# CITY OF ALBUQUERQUE

**Re: Insight Construction, 3909 12<sup>th</sup> Street NW, Traffic Circulation Layout**  
**Architect's Stamp undated (G14-D083)**

Based upon the information provided in your submittal received 07-30-12, the above referenced plan cannot be approved for Building Permit until the following comments are addressed:

1 Traffic Circulation Layout
1" = 10'-0"

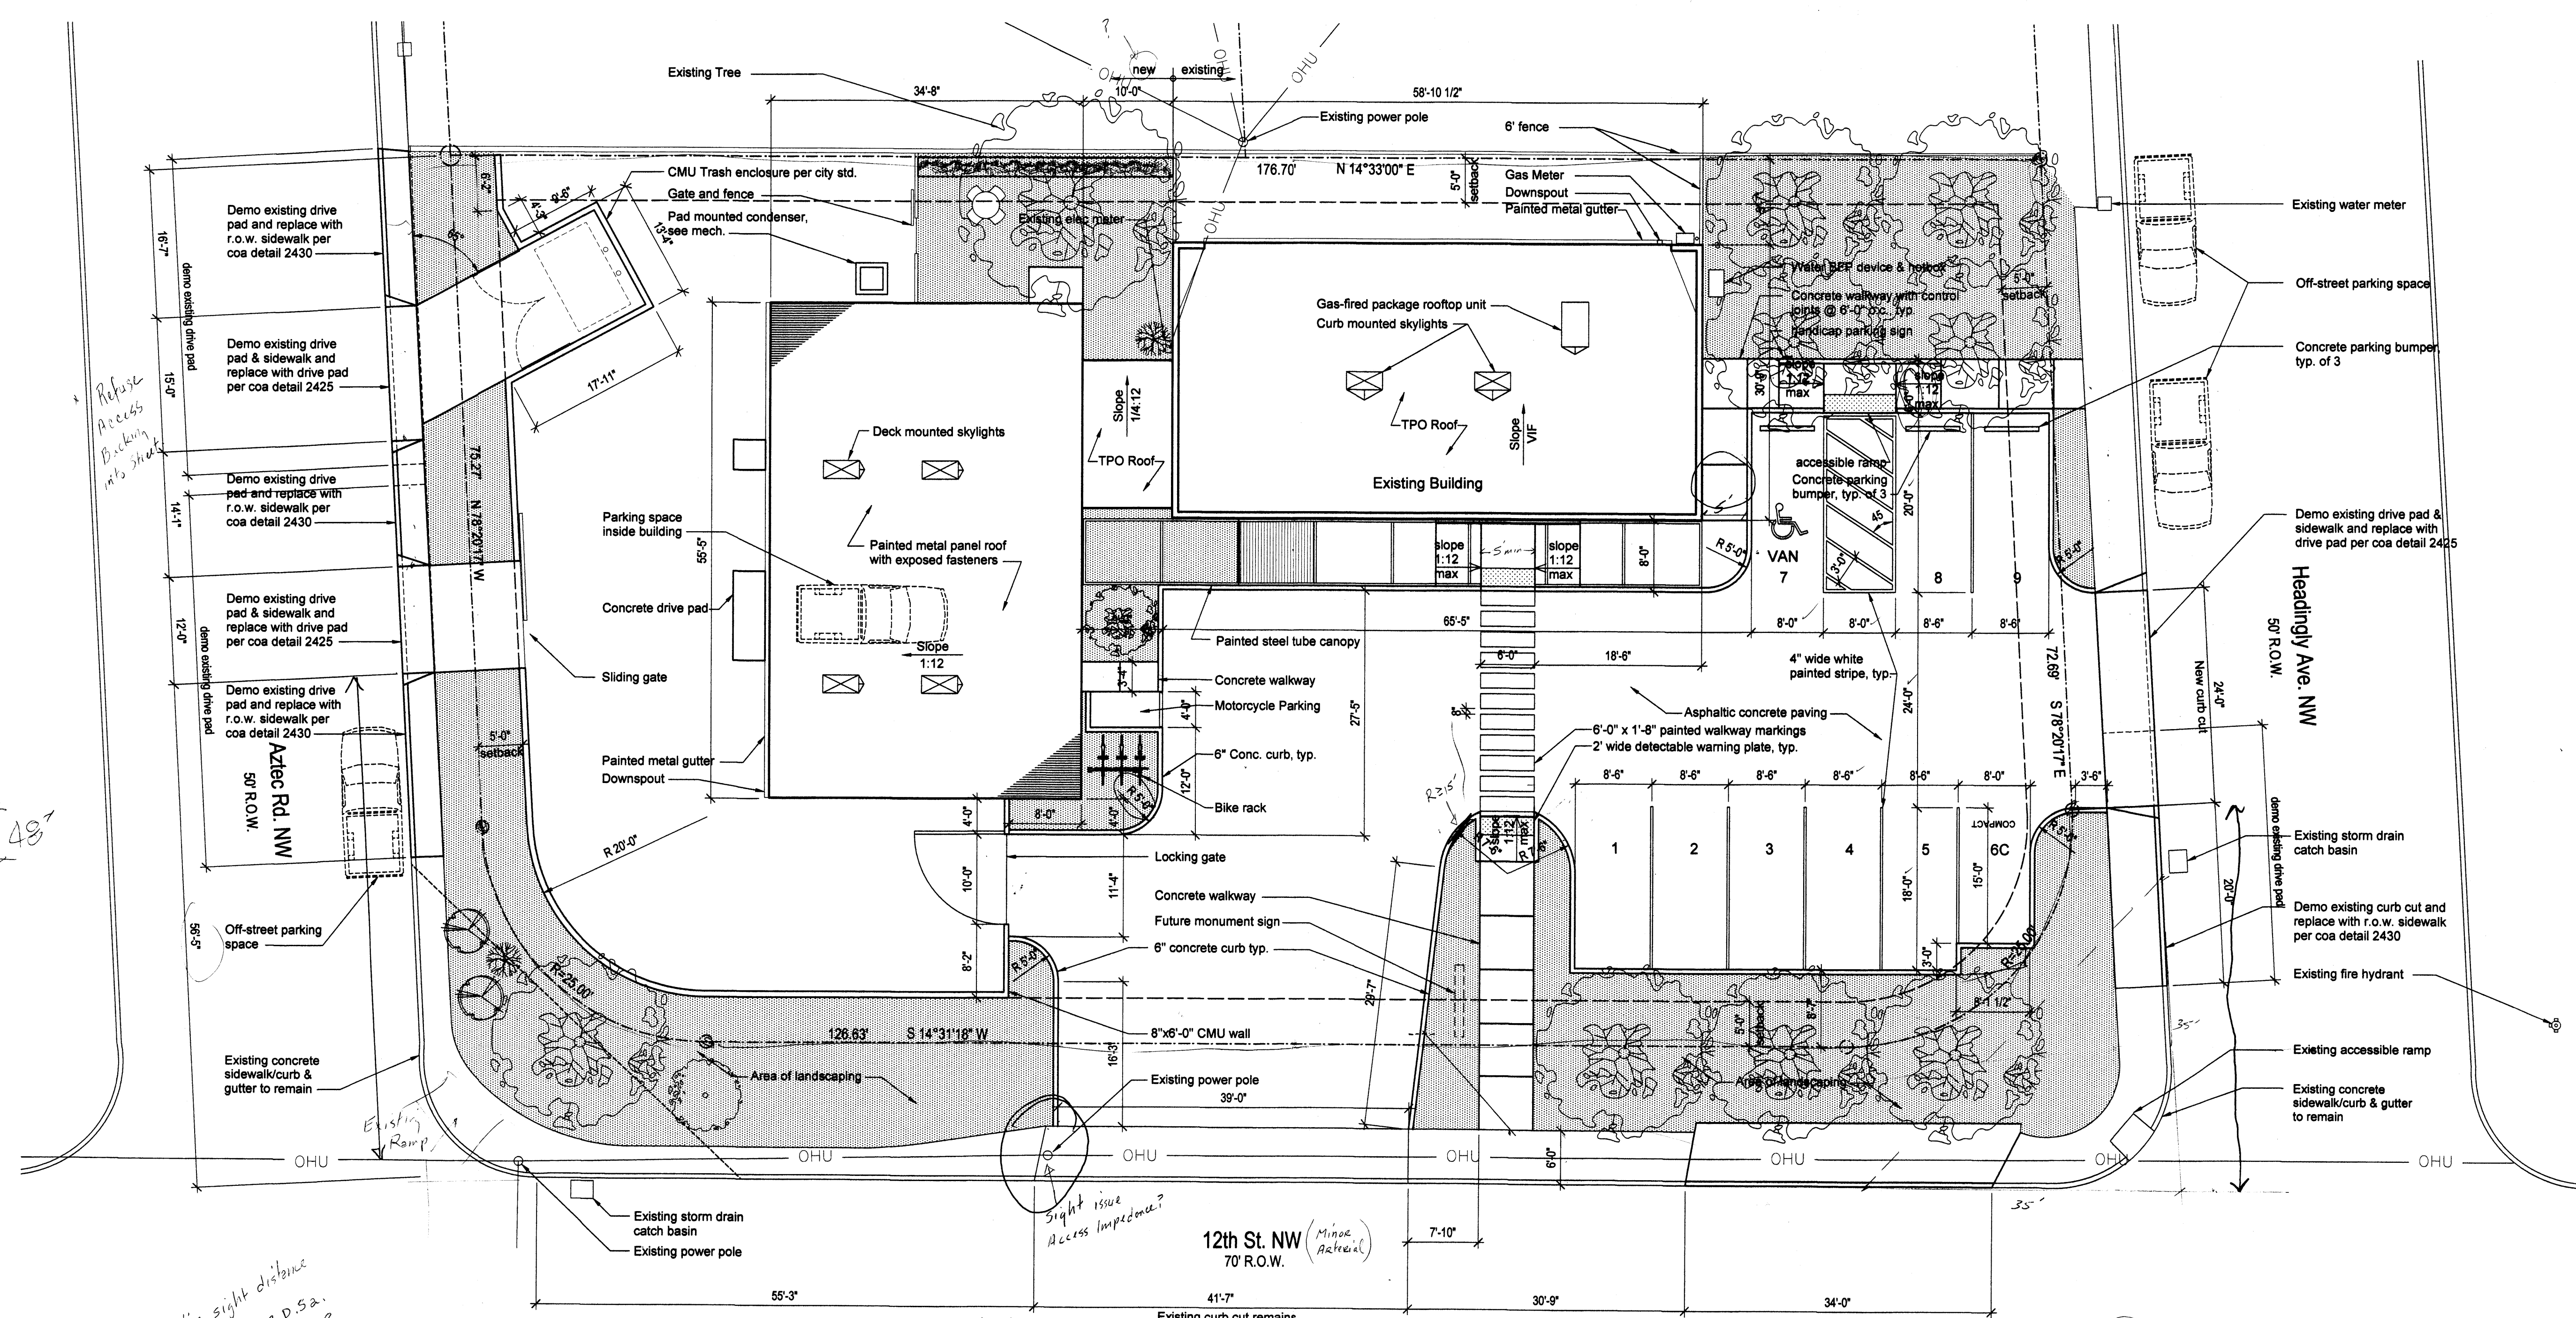
1. List radii for all curves shown; for passenger vehicles, the minimum end island radius is 15 feet.
2. On street parking credits require a separate submittal and review process (please refer to Section 14-16-3-1(E)(6)(d) of the *City of Albuquerque Zoning Code* for further information).

3. Please show the location of the nearest driveway on the adjacent lot.
4. Define the distance from the drive location to the intersection. Please note that a 50-foot distance is required (see the *Development Process Manual*, Chapter 23, Section 6 Part B.5).

5. The "Building and Traffic Circulation Concept" states the curb cut on 12<sup>th</sup> Street was recently rebuilt. Was this curb cut rebuilt by the property owner?

6. Compact parking spaces are permitted only when the premises contain more than 20 parking spaces (see the *Development Process Manual*, Chapter 23, Section 7, Part A).

7. Show all existing ramps; is there a ramp at the corner of Aztec and 12<sup>th</sup>?
8. A 5-foot setback is shown throughout the site; is parking permitted within this setback?

9. Define the width of all sidewalk; please note that a 6-foot minimum width is required for all sidewalk within the site.
10. The traffic circulation layout must be stamped, signed, and dated by an engineer or architect licensed in the state of New Mexico.

11. No obstruction to view between three and eight feet above the gutter line shall be placed or maintained within the clear sight triangle (see Ordinance 8-2-2-15).
